2024/0961

Development: Erection of single storey side and rear extensions, and introduction of cladding to the front elevation, to 2 storey detached dwelling

Address: 4 Woodend Avenue, Cubley, Sheffield, S36 6FX

PROPOSED FRONT ELEVATION  
1:100

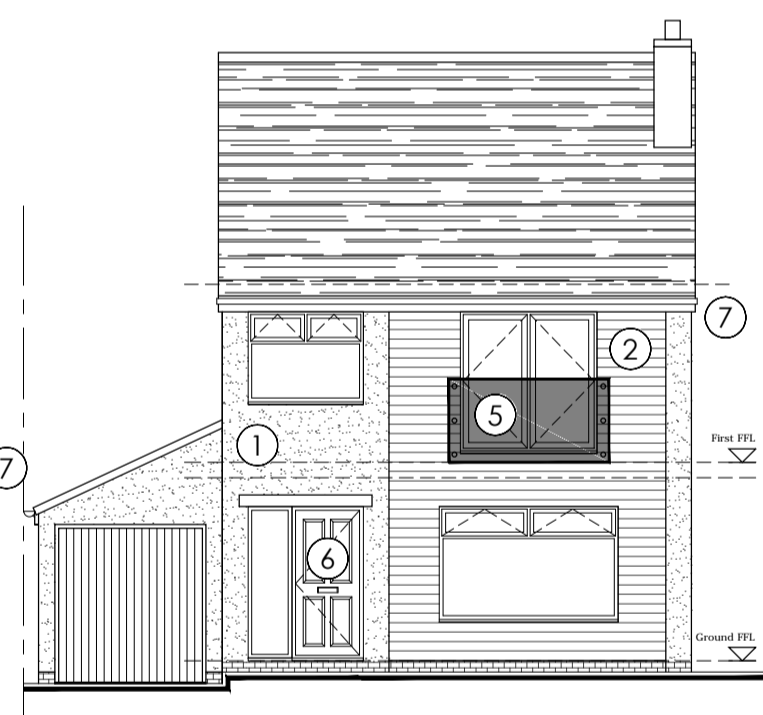
The application also proposes to introduce shiplap cladding in grey to the front elevation of the property. The street scene is characterised by properties with cladding located on the front elevations in many different materials and colours.

PROPOSED REAR ELEVATION  
1:100

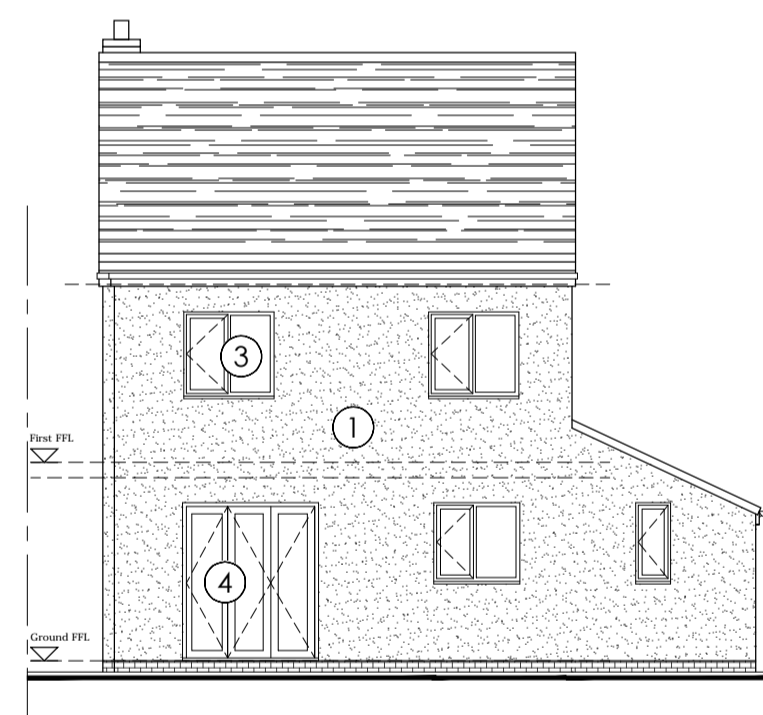
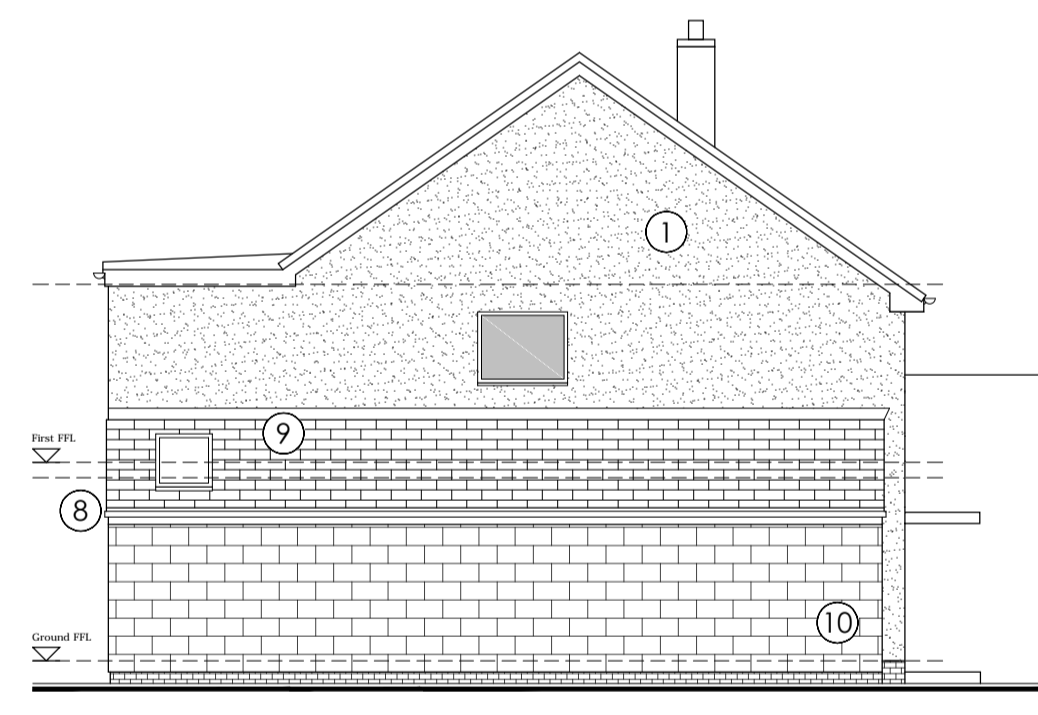
The original application was for the erection of a two-storey rear extension. After discussions with the planning department this element of the proposal was amended. The rear extension will now comprise a single storey rear extension. To the north of the site sits a pair of semi-detached dwellings which are orientated with the rear elevation facing the side profile of the host property. These properties sit under 5m away from the side elevation of the host property. This is further amplified by the height difference between the properties, the host property being at the higher level. Any extension on to the host property will impact these properties in particular number 23. Number 23 has rear facing habitable room windows at both first floor and ground floor levels.

SPD: House Extensions and other domestic alterations states that a distance of 12m should be maintained from a habitable room window and a blank gable wall. The proposal will fall short of this and is proposed to be at a distance of less and 5m away. However, it needs to be noted that the applicant could erect a single storey rear extension on the back of this property of a similar size under permitted development.

Although I acknowledge that any extension to the rear of this property will impact the adjacent properties along Gledhill Avenue, the applicant amended the plans to reduce the two-storey rear extension to a single storey which dramatically reduces the impact to the adjacent properties. When the proposal is also assessed against which could be erected under permitted development and take into account the relatively small projection proposed. On balance although the amended proposal

PROPOSED RH GABLE ELEVATION  
1:100

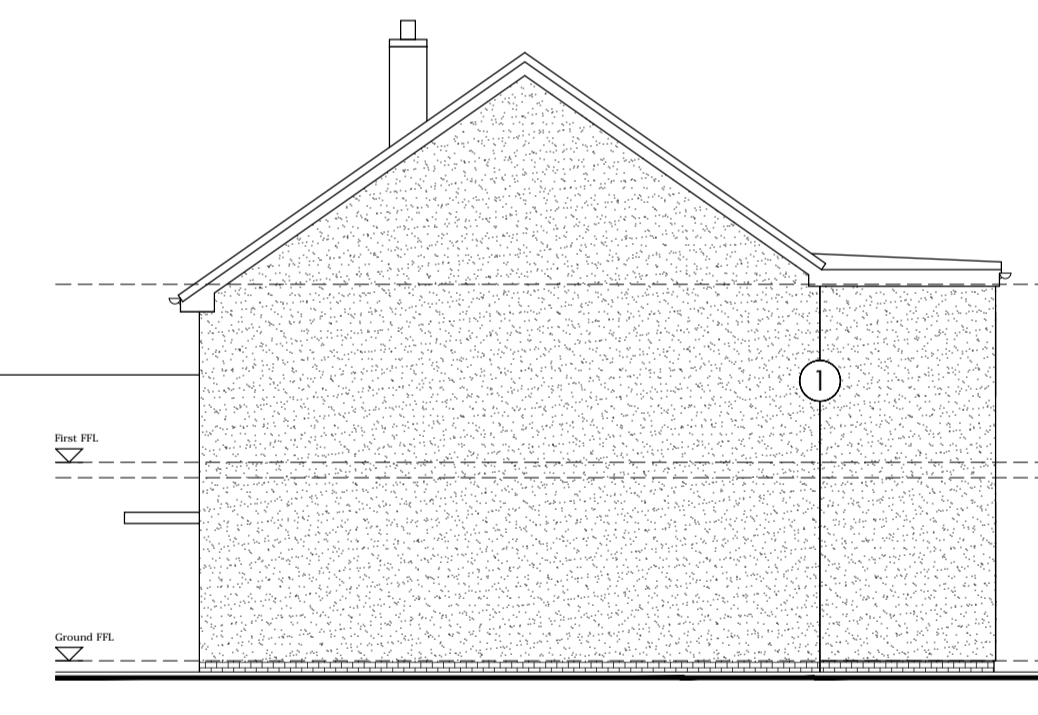
The proposed side extension will be located along the boundary with the neighbouring bungalow. This property has three side facing windows facing the host property driveway. An objection has been received with concerns regarding the impact to these side facing windows. The neighbour has confirmed that one of the windows serves a habitable room. Two windows are small and relatively high level so the impact will be minimal. The impact to the third larger window has been shown on the amended plans, and although it is acknowledged that this third window will be somewhat impacted SPD: House Extensions states that the Council will seek to protect principle habitable room windows on the front and rear elevations of the adjacent property, but not secondary windows, particularly those on side elevations of adjacent dwellings. Therefore, although habitable room windows are protected in terms of planning policy, secondary windows located on the side elevation are not afforded the same protection. That said, the applicant has provided details within the amended drawing to show that there is unlikely to be a substantial effect on daylight to the window of concern.

The host property is located on Woodend Avenue which is characterised by dwellings of a similar appearance. The street scene is characterised by brick-built properties partly clad on the front elevation. The original application proposed render however this was not deemed appropriate within this location due to the visual impact on the street scene. The applicant amended the plans to show the side extension to be constructed in matching brick and block work to be located on the side elevation which will not be viewable within the street scene.
